Our Ref: 2022/231491
File No: R/2014/13/L

Sydney Modern – Art Gallery of NSW – SSD 6471 Modification 8

Thank you for your correspondence dated 24 March 2022 which invites the City of Sydney (“the City”) to provide comment on the proposed modifications to approval SSD 6471 which largely comprise minor architectural and landscape design changes.

Figure 4 | Modified landscape design of forecourt plaza (Base source: RTS proposed landscape plan)

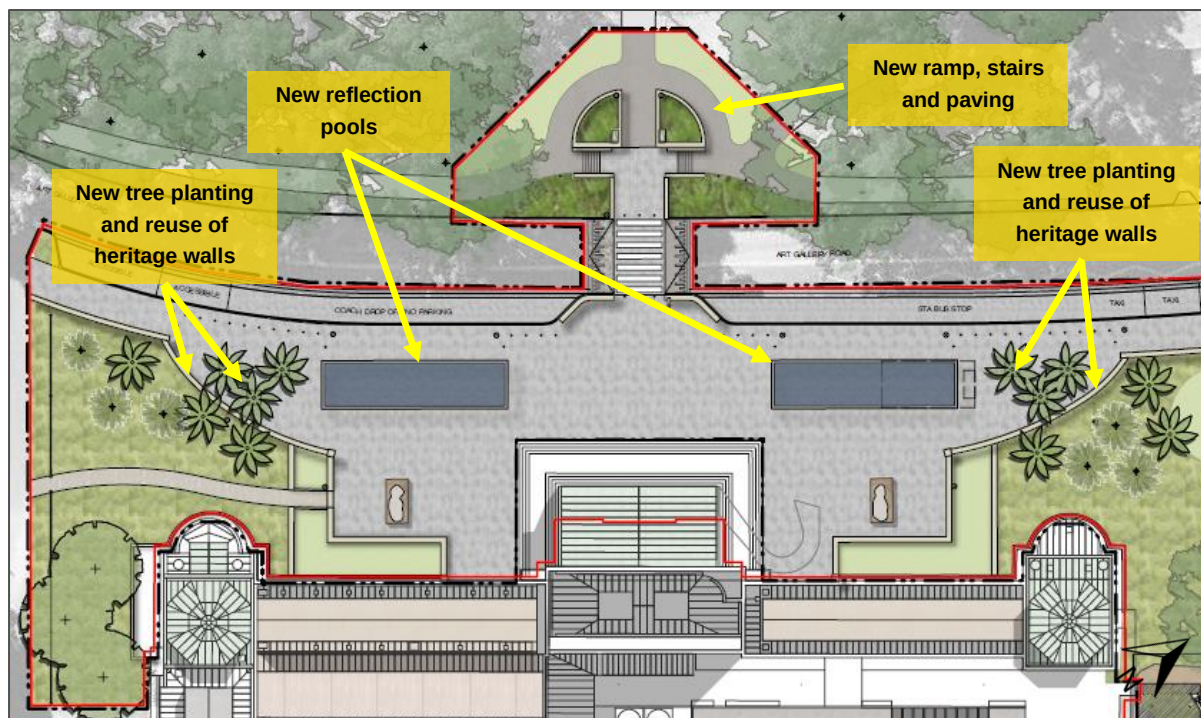
It is positive to see that the bollards to the AGNSW forecourt are finally aligned as the City had requested as part of the consultation done in accordance with Condition B20 New Steps, Ramp and Pedestrian Control Structures and Hostile Vehicle Management.

In this regard our recommended spacing between the bollards is 1400mm, as this would allow the forecourt to still feel open, inviting and more permeable to those on foot. Furthermore, our City Design unit are currently working with the original designers of the City’s Street furniture suite to provide design options for a shroud that can be installed over existing structures such as the EZI security truck stopper footing, and there is willingness to share that with you to ensure aesthetic uniformity.
